Item No. **Report of the Head of Development Management and Building Control**

Address: 60 LANSBURY DRIVE HAYES

Development: Conversion of single dwelling house into 1no. 2-bedroom and 1no. 1-bedroom flats with amendments to rear fenestration, associated parking, amenity space, bin storage and bicycle storage (amended description).

LBH Ref Nos: **16477/APP/2025/1616**

Site Address:		Title:		Drawn By: VG	
60, Lansbury Drive, Hayes, UB4 8SD		Proposed Site Plan		Job Ref: 22058	
Scale:	N/A	Paper Size:	A3	Date:	Jun 2025
				Drawing No.	PL - 07

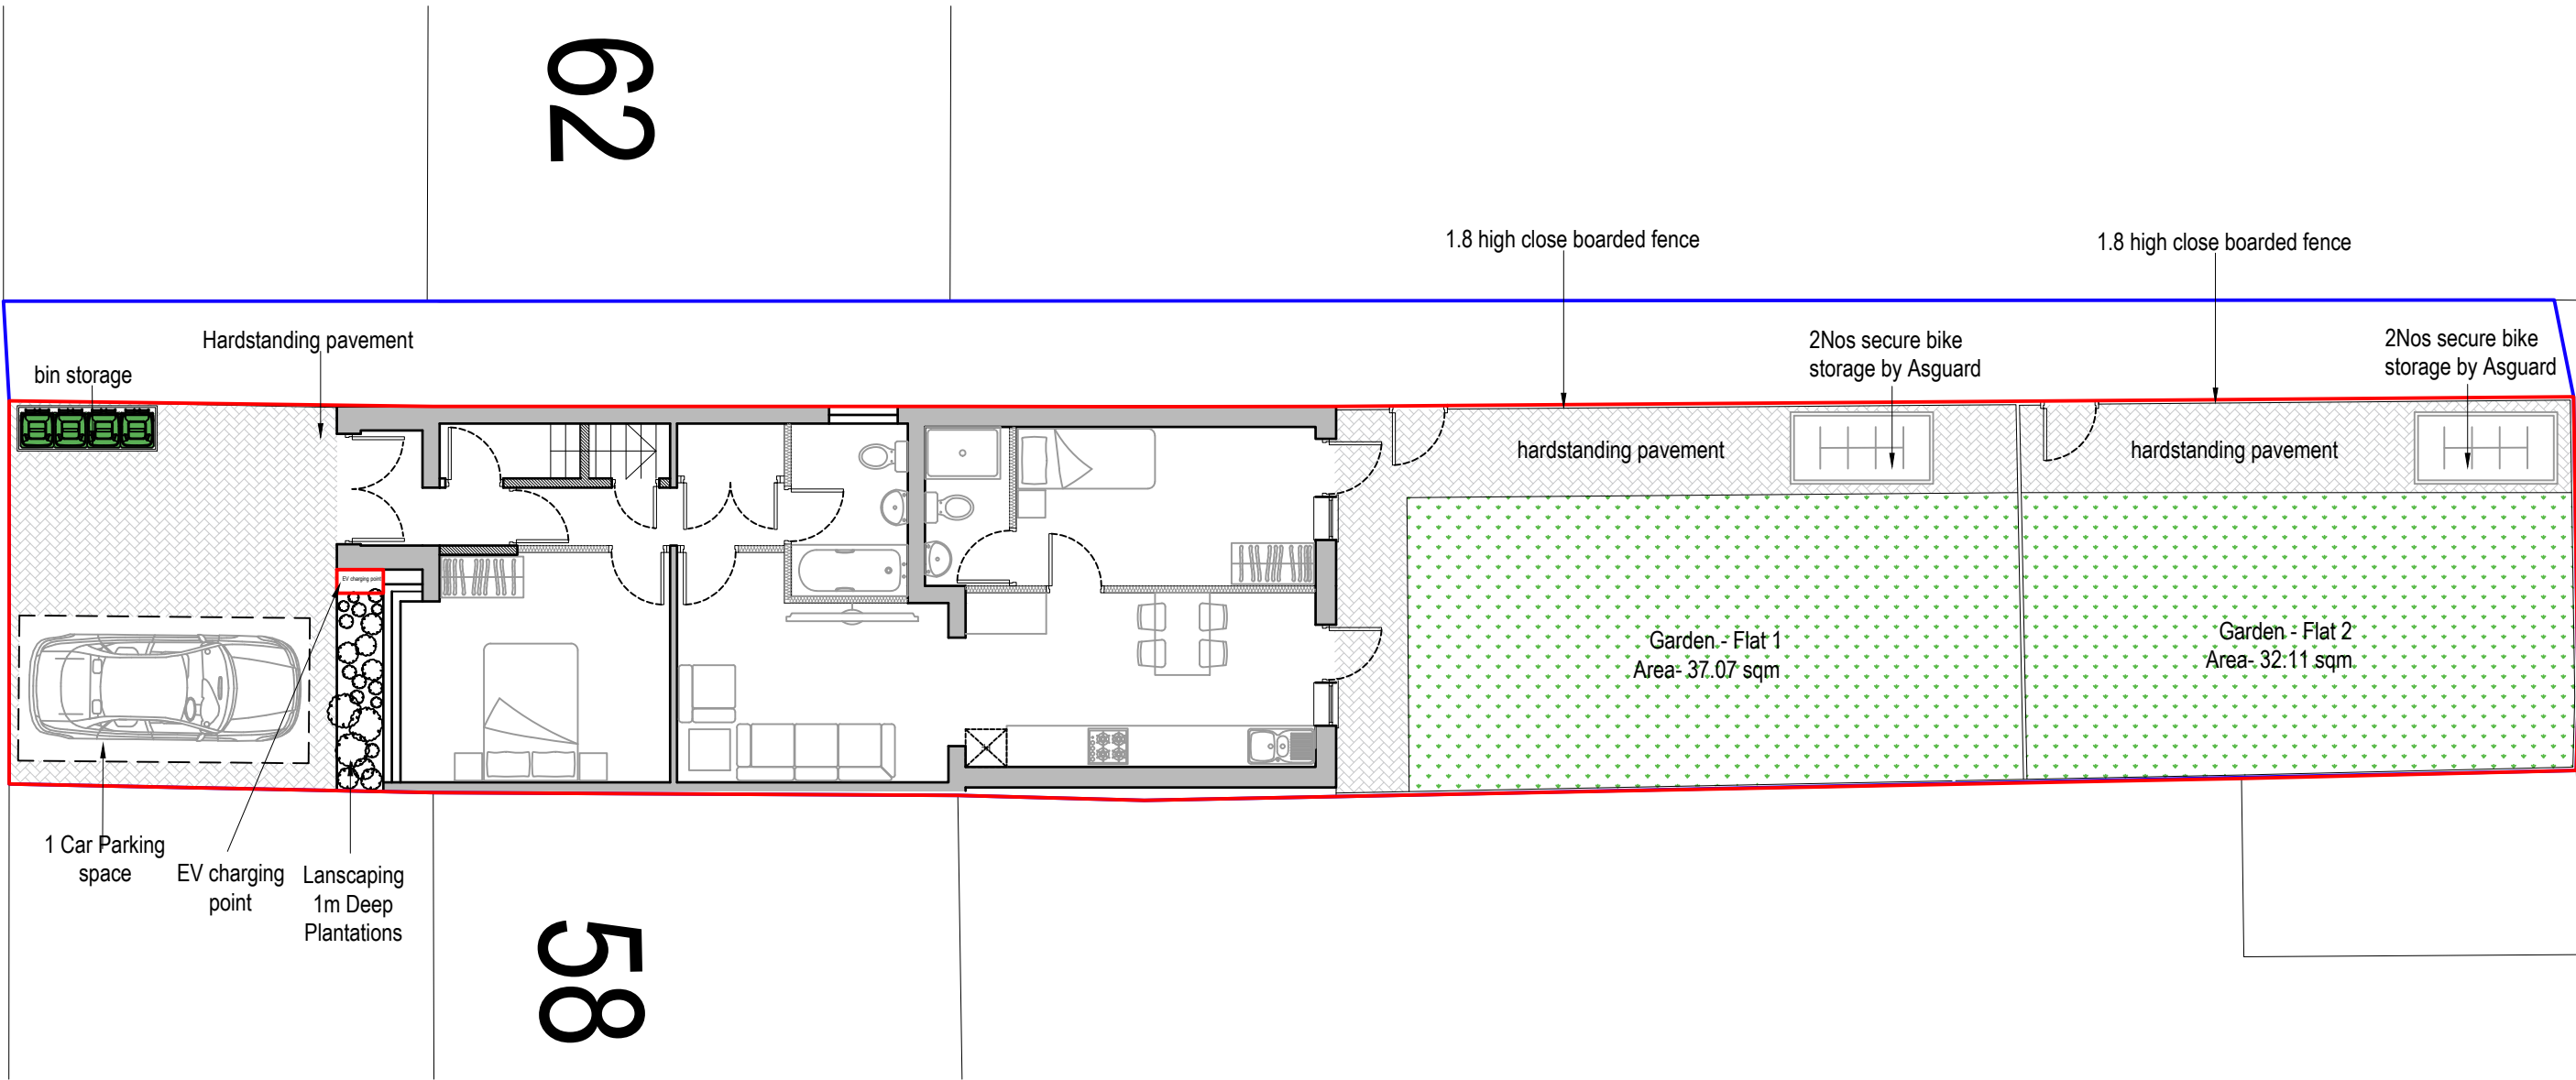
The car parking layout is not acceptable which is shown at an angle, parking bays must be perpendicular to the public highway, therefore to avoid obstructing pedestrian access at the entrance the parking should be at the southern end of the forecourt and bin storage located to the northern end, therefore landscaping in the forecourt which does not allow vehicle parking perpendicular to the public highway will need to be removed.

The car parking layout is not acceptable which is shown at an angle, parking bays must be perpendicular to the public highway, therefore to avoid obstructing pedestrian access at the entrance the parking should be at the southern end of the forecourt and bin storage located to the northern end, therefore landscaping in the forecourt which does not allow vehicle parking perpendicular to the public highway will need to be removed. The HA believes that there is sufficient scope for the applicant to satisfactorily address the above requirements and therefore could be conditioned should the application have been recommended for approval.

Before the occupation of the proposed development, detailed plans showing the car parking layout (including dimensions) away from the buildings entrance and EV charging point in accordance with the London Plan and Policy DMT6/5 shall be submitted to and approved in writing by the Local Planning Authority. The car parking layout and EV charging point shall be constructed and laid out in accordance with the agreed details and completed prior to occupation of the development hereby approved and shall thereafter be retained, maintained, and kept available for the occupants of the development at all times.

Drawing No. PL - 05

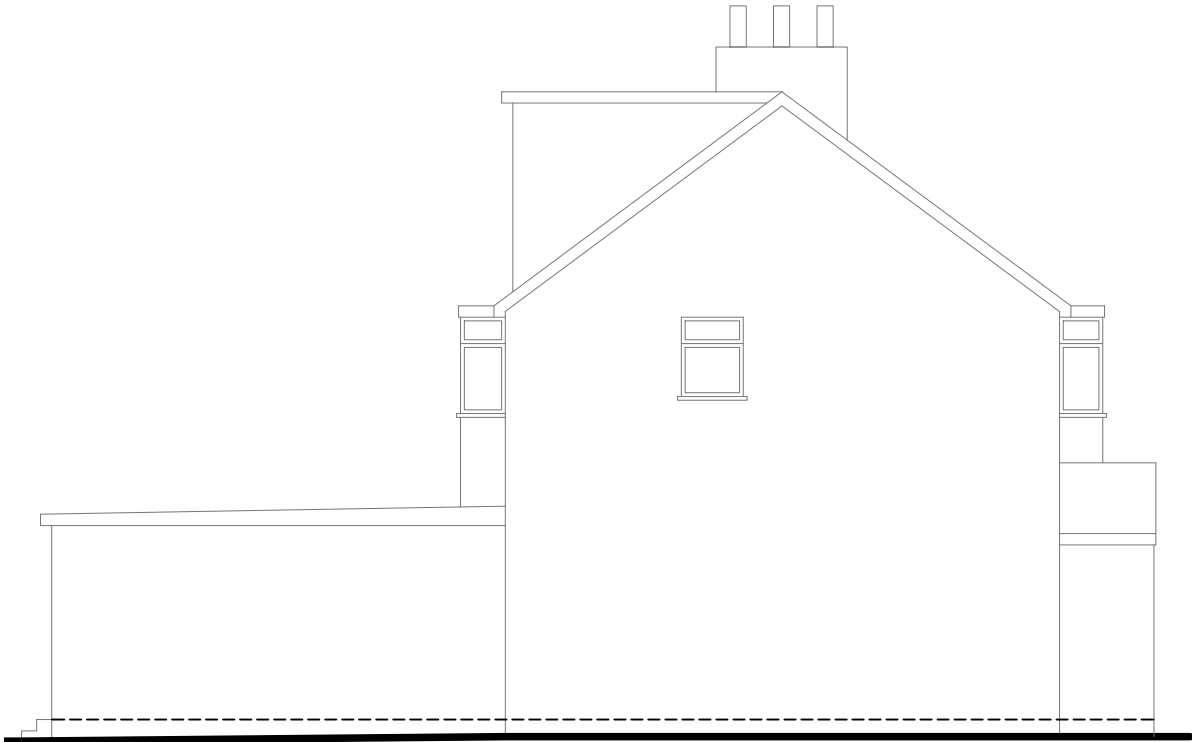
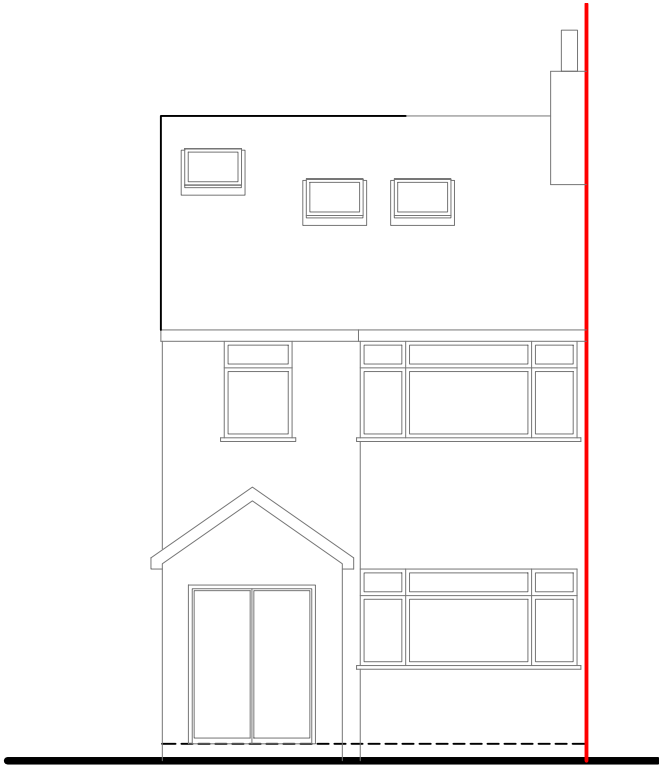
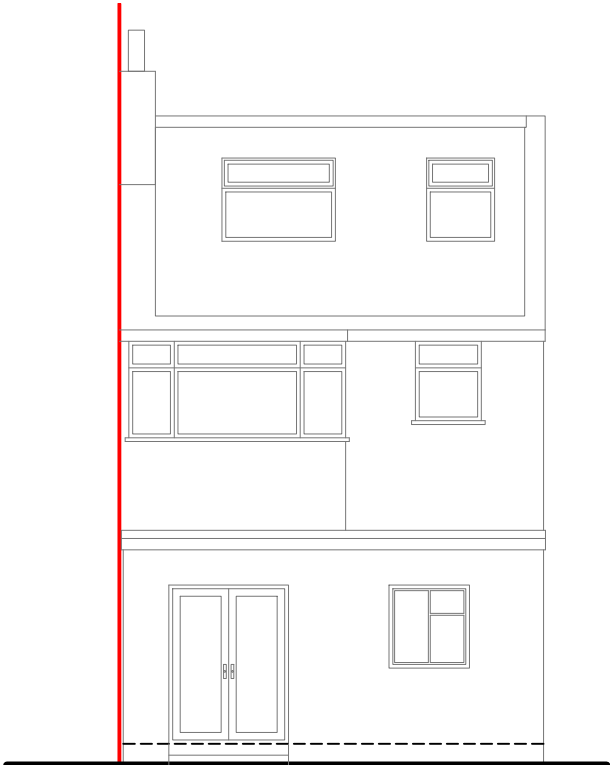
There are no proposed extensions associated with the development, the only external alterations would be the change in fenestrations to the ground floor rear of the property. The development would include new windows and doors within the existing rear extension to provide additional

There are no additional extensions proposed as part of this development. The only external changes would be alterations to the ground floor rear fenestrations to include two doors and two windows. This is not considered to cause harm to the character and appearance of the existing property nor the surrounding area given it is located to the rear and not visible from the street scene. A condition would have been secured to ensure the proposed materials match existing.
